Recommendation Report for Planning Permission for Works or Extension to a Dwelling

REF NO: BE/159/12/

LOCATION: 24 Ashurst Close
North Bersted

PROPOSAL: Two storey side extension

PROPOSED FIRST FLOOR

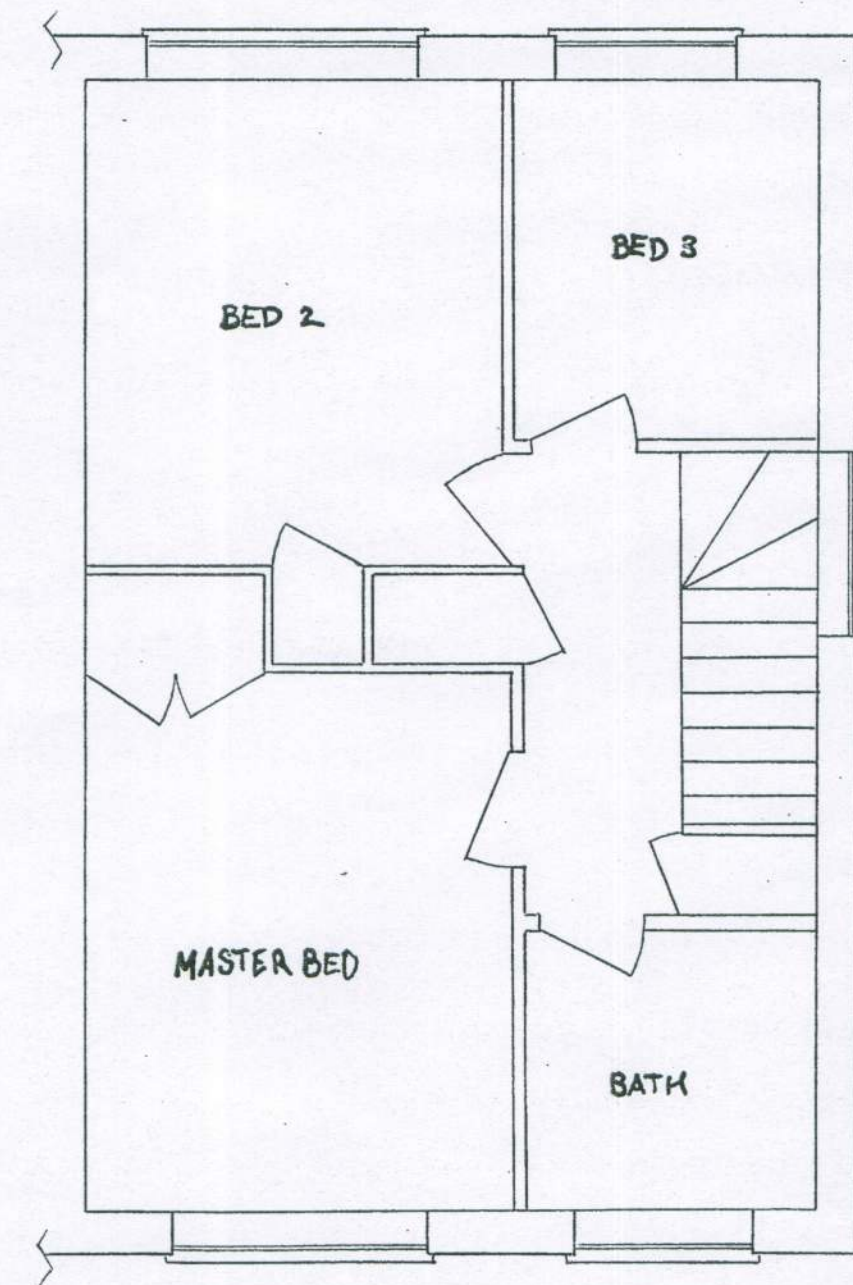
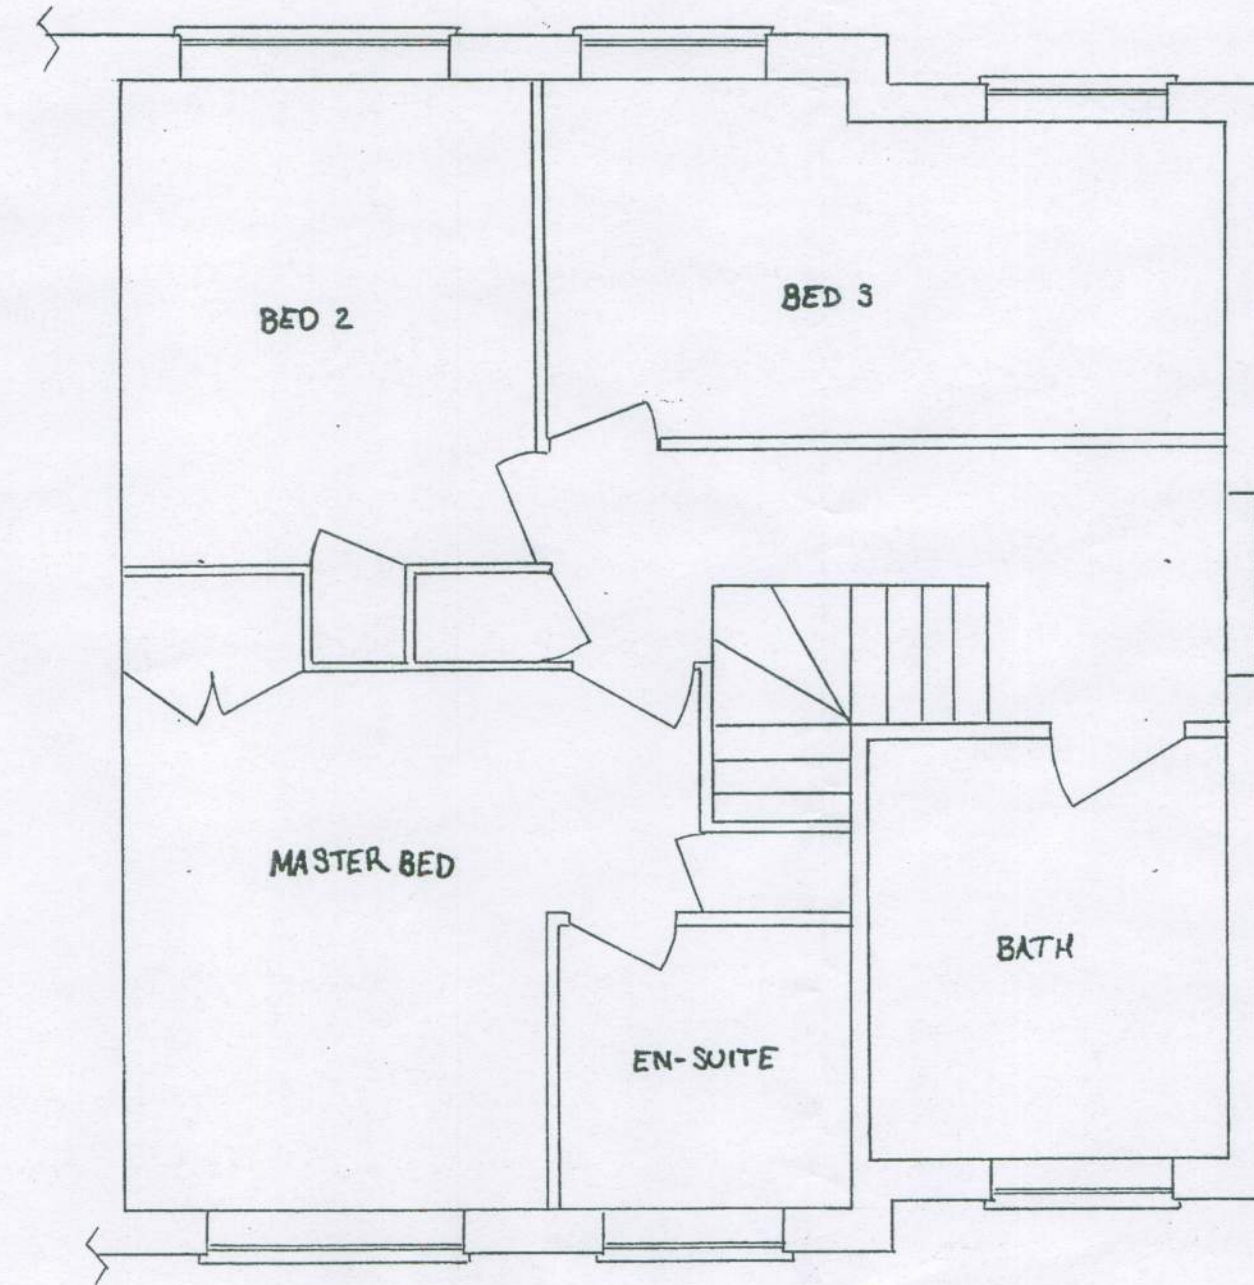
The Council would like the rear window to be obscure glazed and there is a 2m boundary space from the neighbouring fence.

The purpose of the proposed extension is to provide for adequate bedroom space for the applicant's growing sons and involves extending the third bedroom which is currently a tiny box room. This room already has a window in the rear elevation. Obscure glass is not normally fitted in bedroom windows and overlooking is not considered a problem with existing trees and shrubs giving adequate privacy. The existing fence is not on the boundary, a new fence will be erected in the correct position on completion of building works.

The application is to consider the extension and the replacement of fencing under 2m may be "permitted development". It is not appropriate to impose a condition that the rear bedroom window be obscure glazed as it is not considered that this would create any unacceptable overlooking that currently exists from the windows at first floor level.
